## Tween Bridge Solar Farm

### 8.17 Written Summary of Oral Submissions at the Issue Specific Hearing 3

Document Reference: 8.17

Deadline 3 June 2026

Drawing file: published-documents / EN010148-000871-6.4.6.2 Environmental Statement Figure 6.2 Landscape Character Areas (Rev 2).pdf

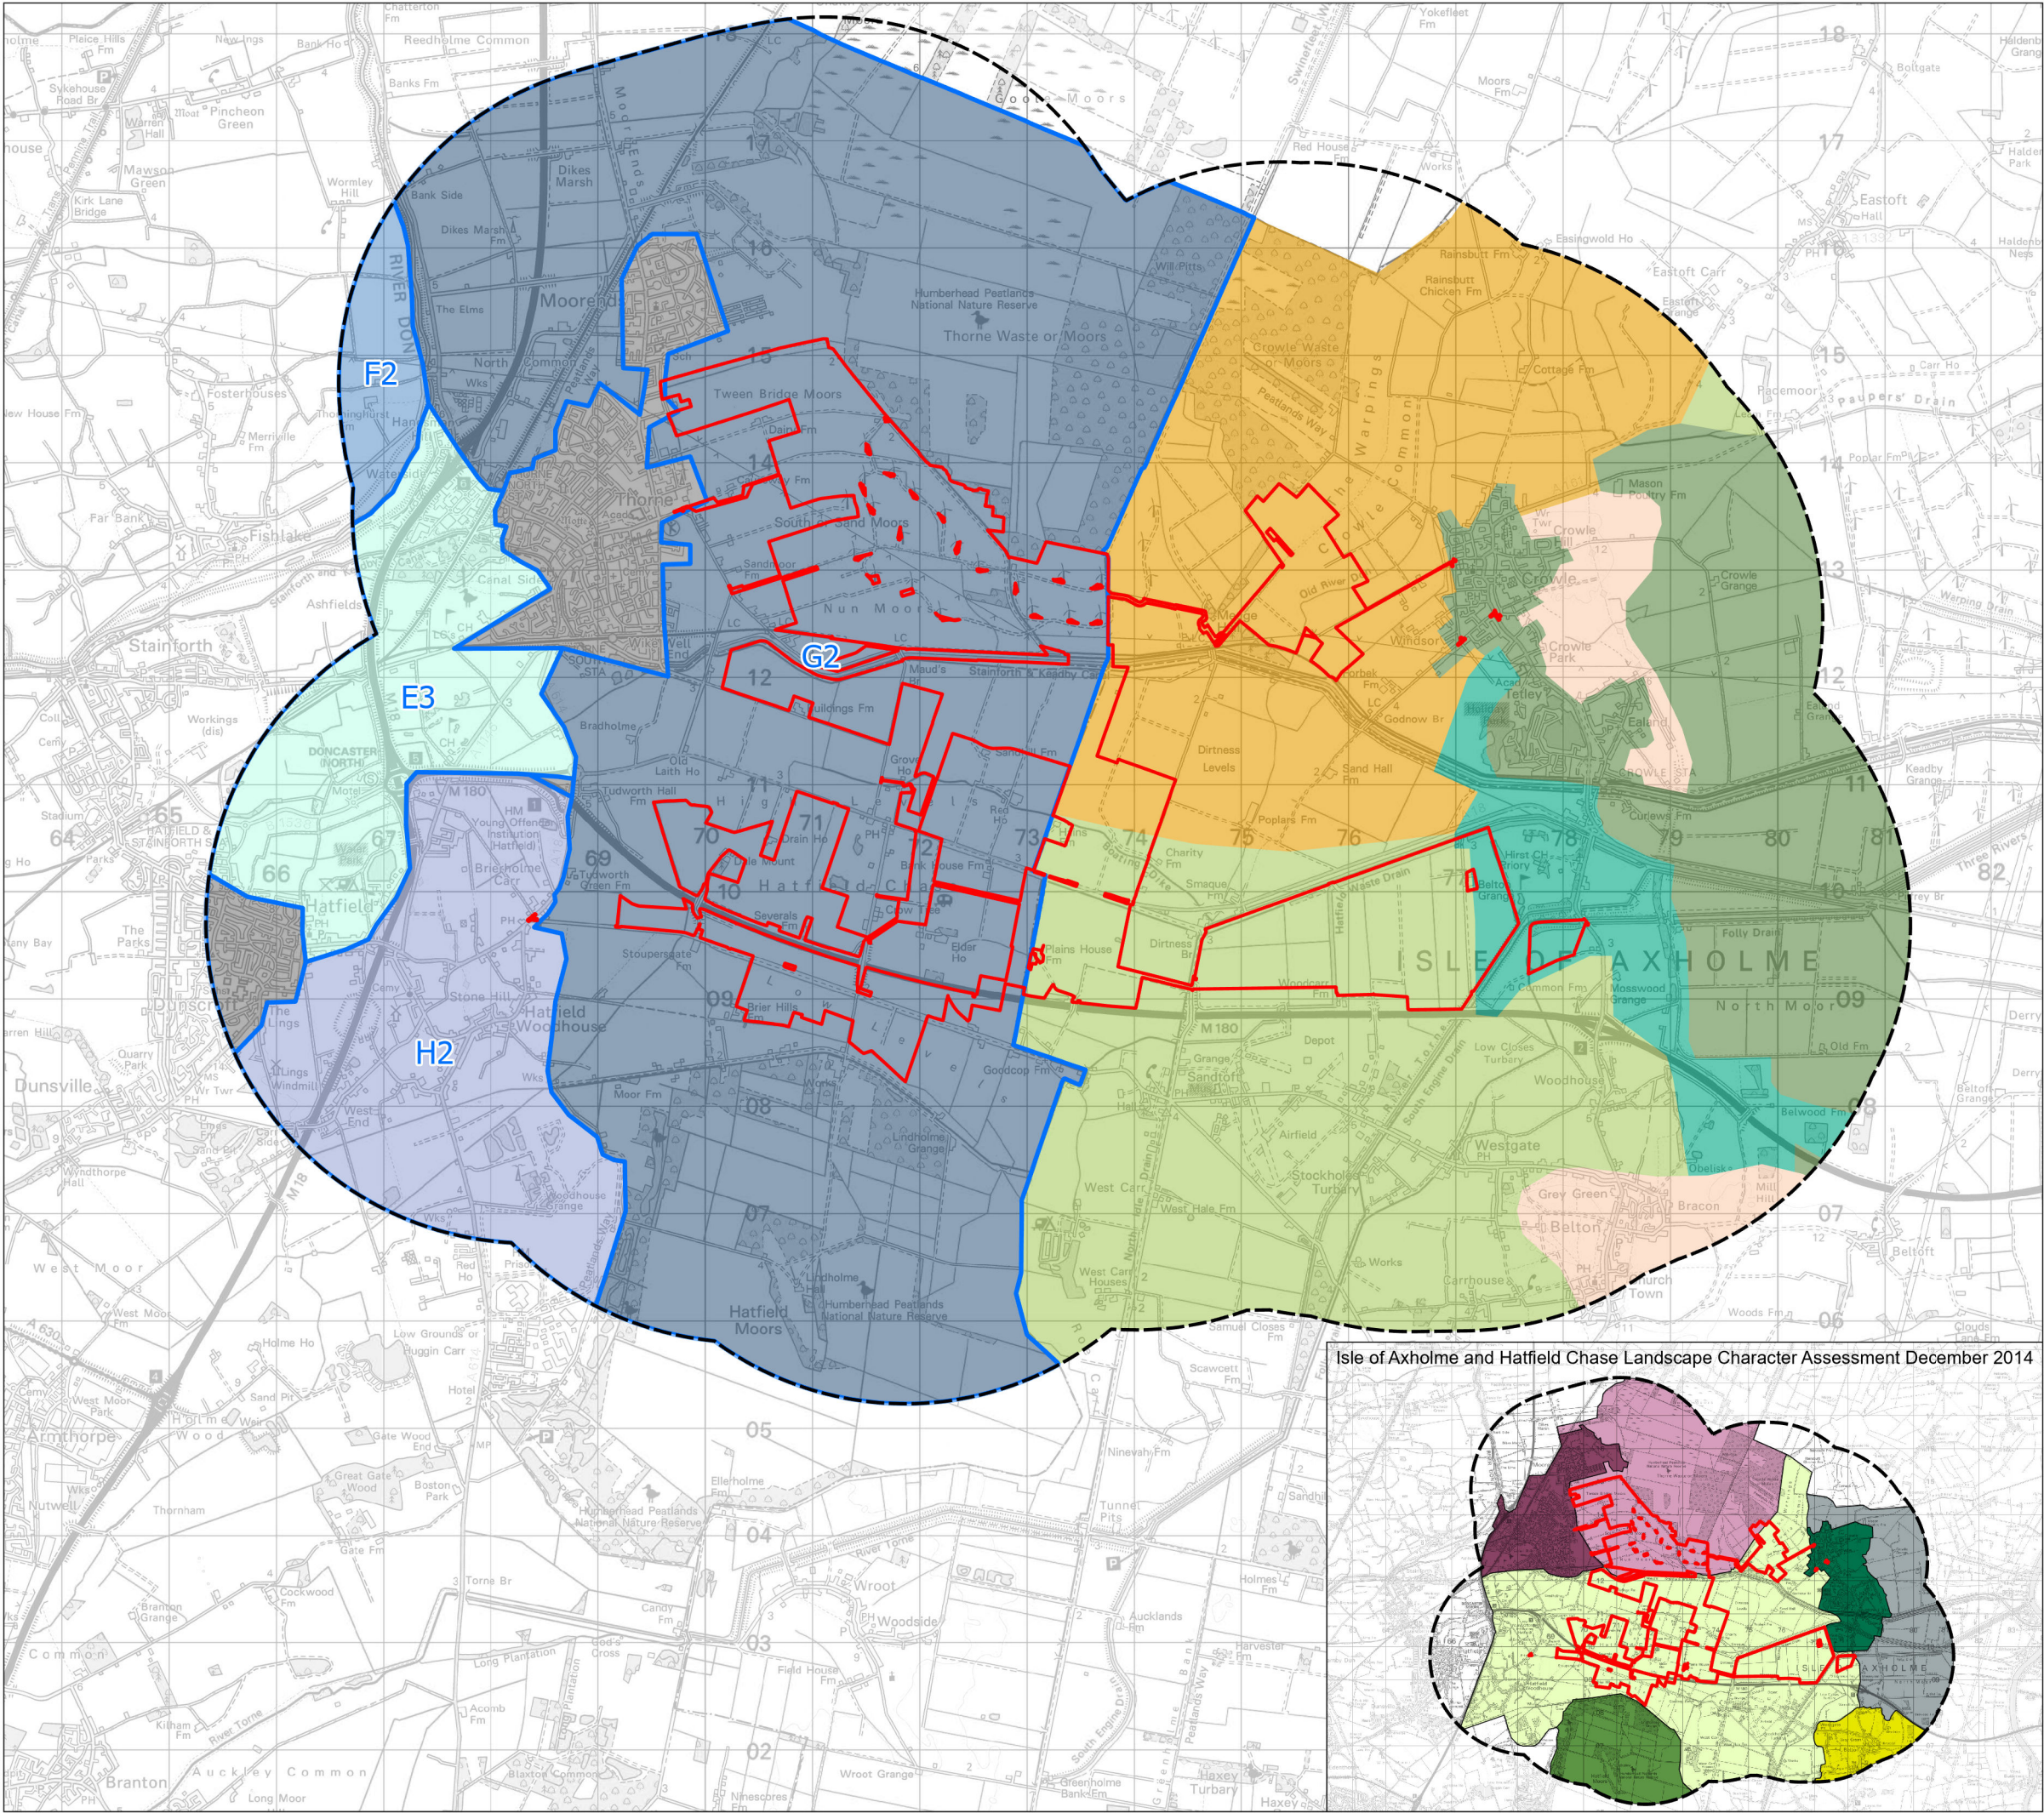
4.2. The ExA drew attention to paragraph 10.15 of **CDC’s Local Impact Report [REP1-062]** in relation to landscape character sensitivity. The ExA summarised the Council’s position and sought clarification as to why the nature of the Scheme and the detailed landscape baseline justified a “very high” sensitivity rating.

4.3. Ms Jones made submissions on behalf of CDC, suggesting a need for a more detailed assessment of landscape character areas. CDC submitted that certain areas may warrant classification as valued landscapes and therefore a higher

sensitivity rating. Ms Jones further noted that more recent landscape character assessments should have been given greater weight in the Applicant's assessment, including the Isle of Axholme and Hatfield Chase Landscape Partnership Assessment (2014) and the North Lincolnshire Landscape Character Assessment (2021) prepared by JBA as part of the emerging Local Plan. Ms Jones acknowledged that these documents are not formally adopted by the Council but submitted that they provide a more up-to-date and detailed understanding of landscape character than the currently used assessment documents.

- 4.10. **Action 1: The Applicant agreed to update ES Chapter 6 Landscape and Visual to take account of the Isle of Axholme and Hatfield Chase Landscape Partnership Assessment (2014) and the North Lincolnshire Landscape Character Assessment (2021).**

- 4.11. **Post-hearing note: The applicant will submit an updated ES Chapter 6: Landscape and Visual [Document Reference 6.2.6 Revision 4] and updated ES Figure 6.2 Landscape Character Areas [Document Reference 6.4.6.2 Revision 2] at Deadline 4.**
